<input type="checkbox"/> 1 - Reviewed, No Exception Taken	
<input checked="" type="checkbox"/> 2 - Reviewed, Revise as Noted	
<input type="checkbox"/> 3 - Revise and Resubmit	
<input type="checkbox"/> 4 - Rejected	
<input type="checkbox"/> 5 - Other, Held for Record, Not Reviewed	
<p>This review is only for general conformance with the design concept and the information given in the Contract Documents. Corrections or comments made on the shop drawings during this review do not relieve the Contractor from compliance with the requirements of the Contract Documents and applicable laws, codes and regulations. Review of a specific item shall not include review of an assembly of which the item is a component. The Contractor is responsible for: dimensions to be confirmed and correlated at the jobsite; information that pertains solely to the fabrication; processes, means, methods, techniques, sequences and procedures of construction; coordination of the Work with that of all trades and performing all Work in a safe and satisfactory manner.</p>

REVIEWER: SJL	DATE: 06.23.13

# University of Southern Maine Payson Smith Building Fire Alarm System Replacement Portland, ME

FIRE ALARM RISER DIAGRAM, NOTES, LEGEND

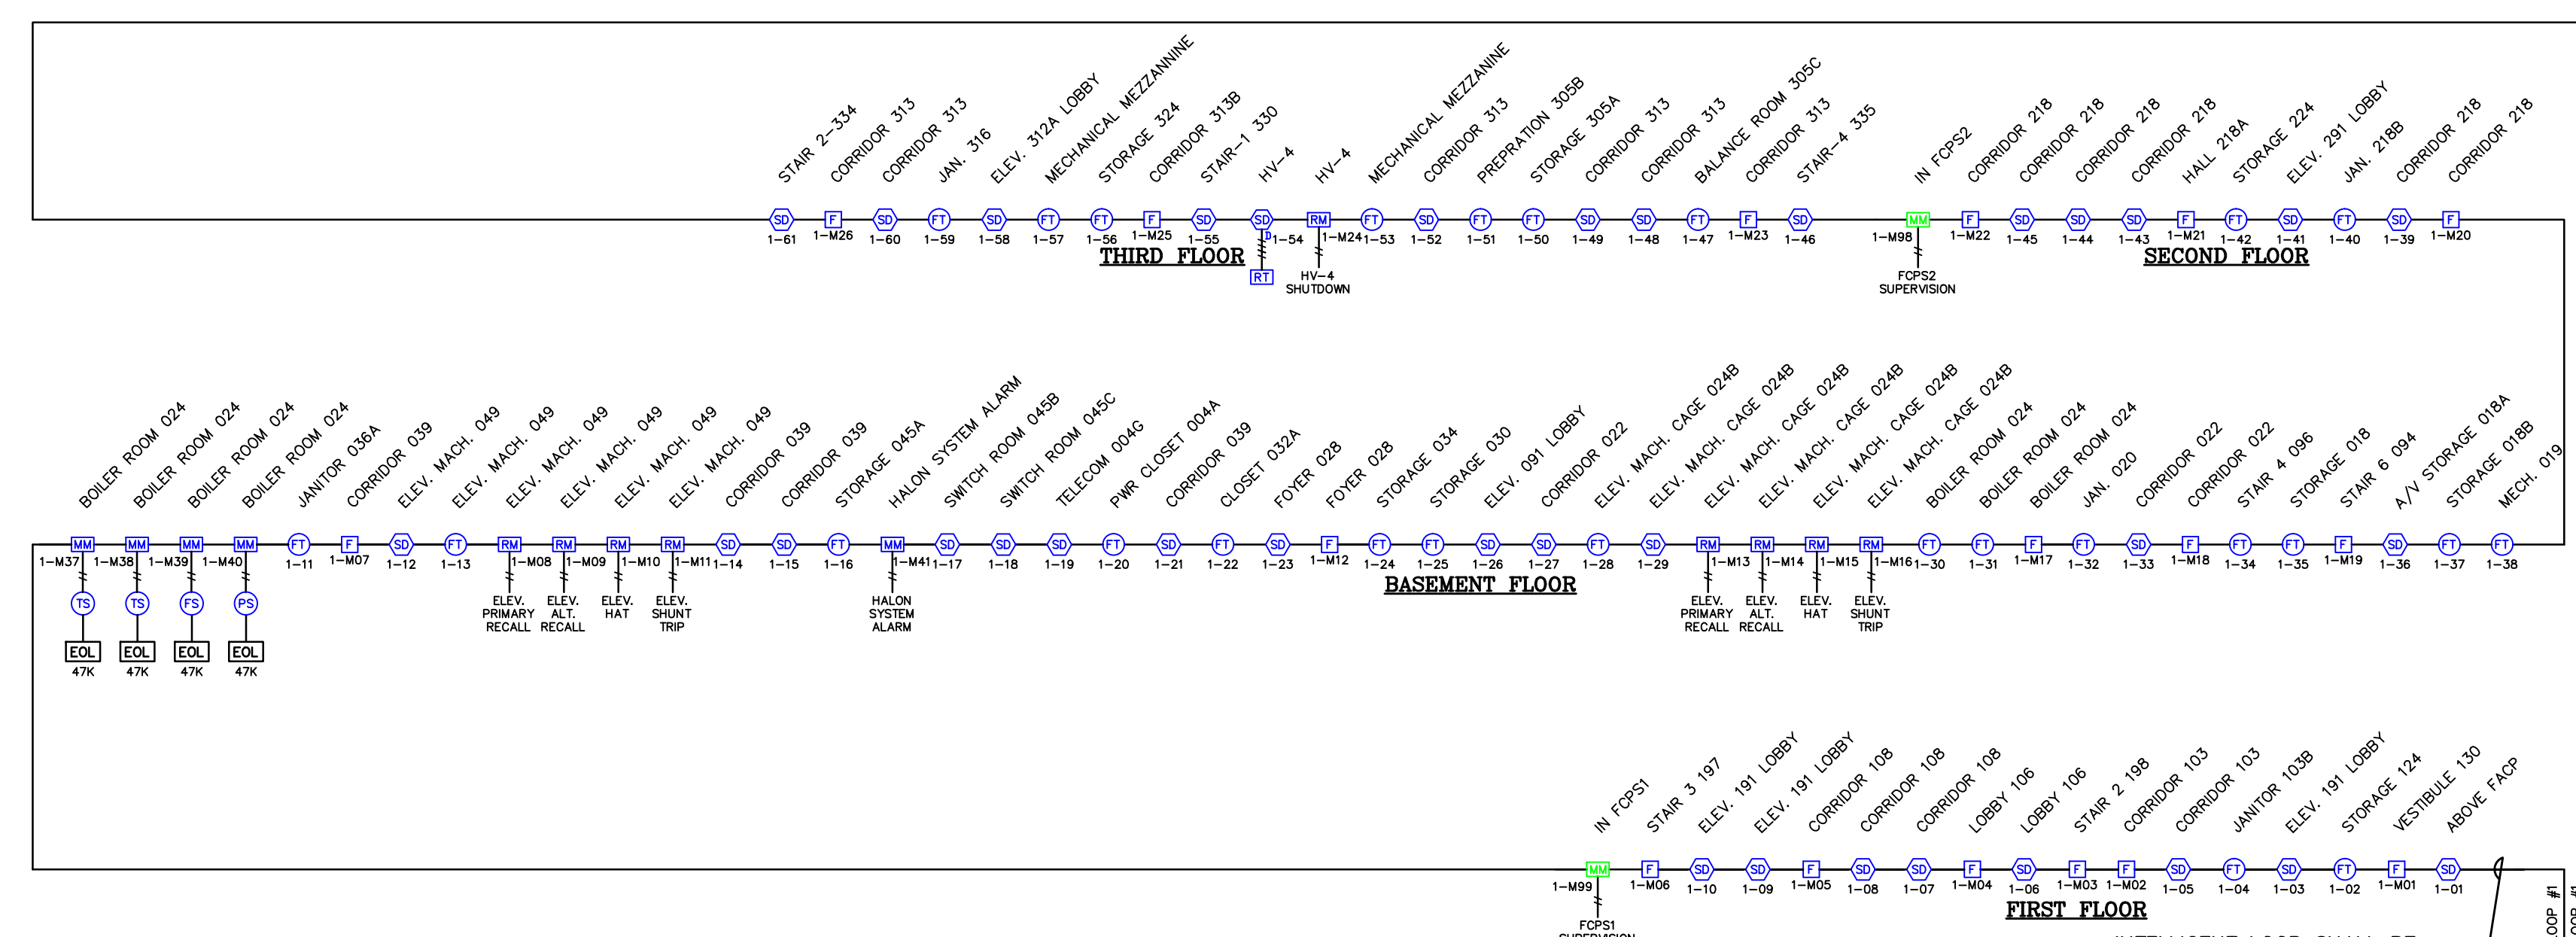
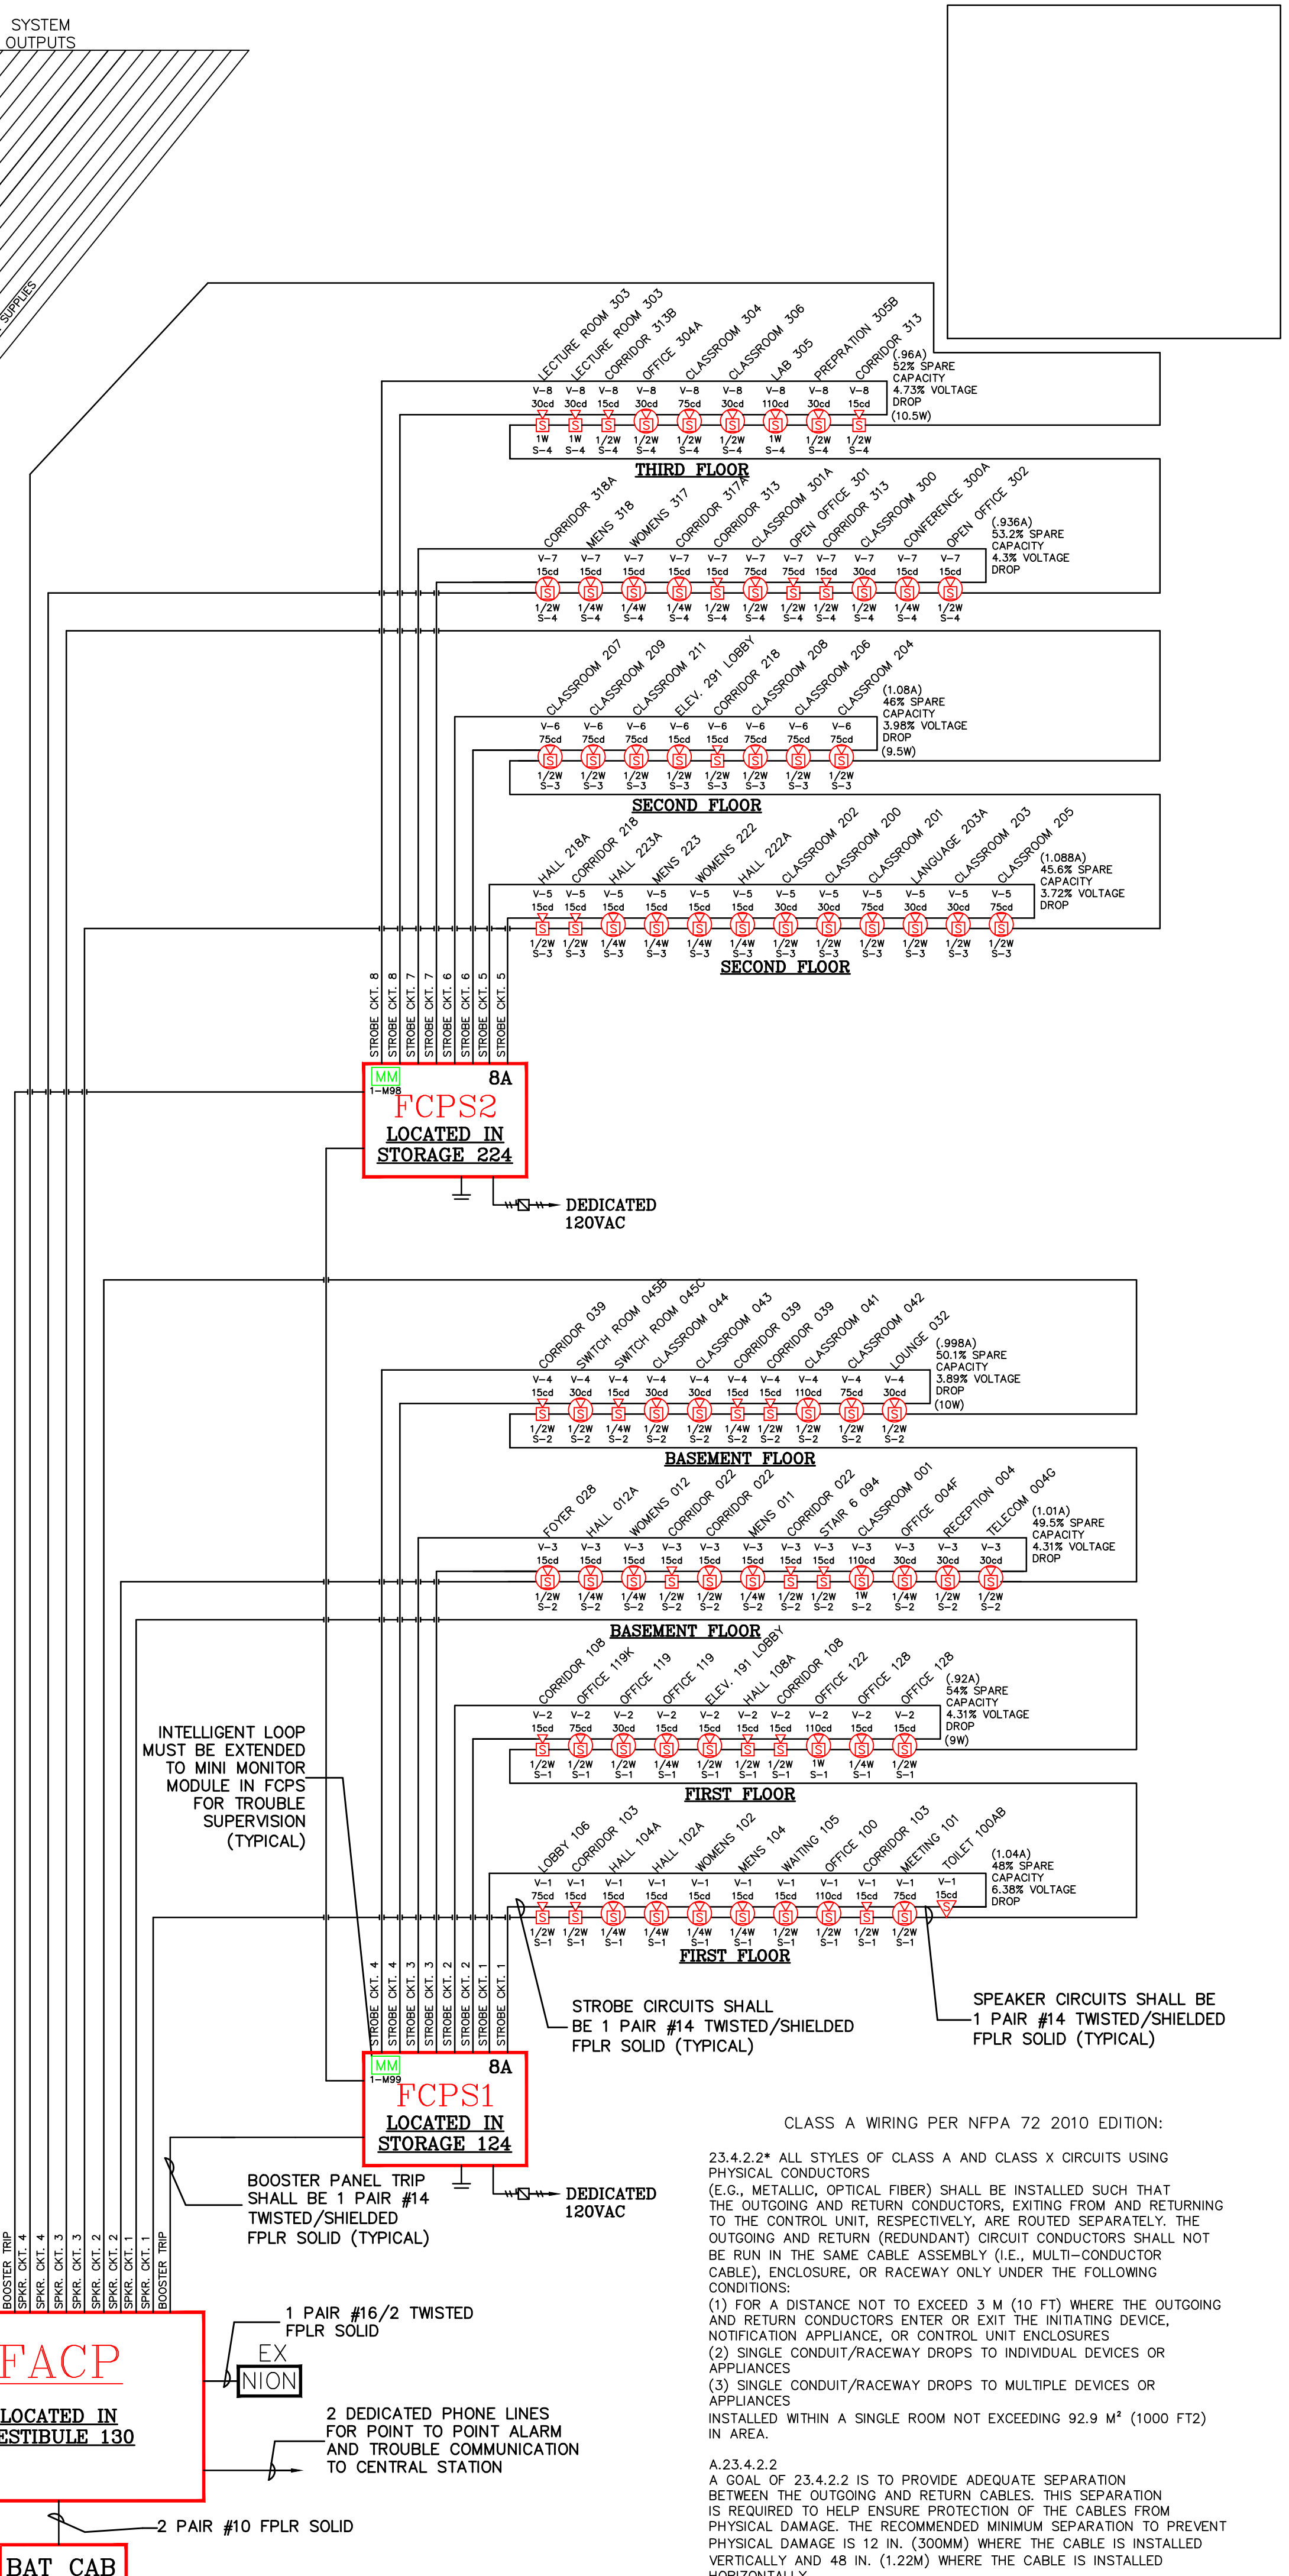
Notification devices submitted as red. Provide white devices as specified.
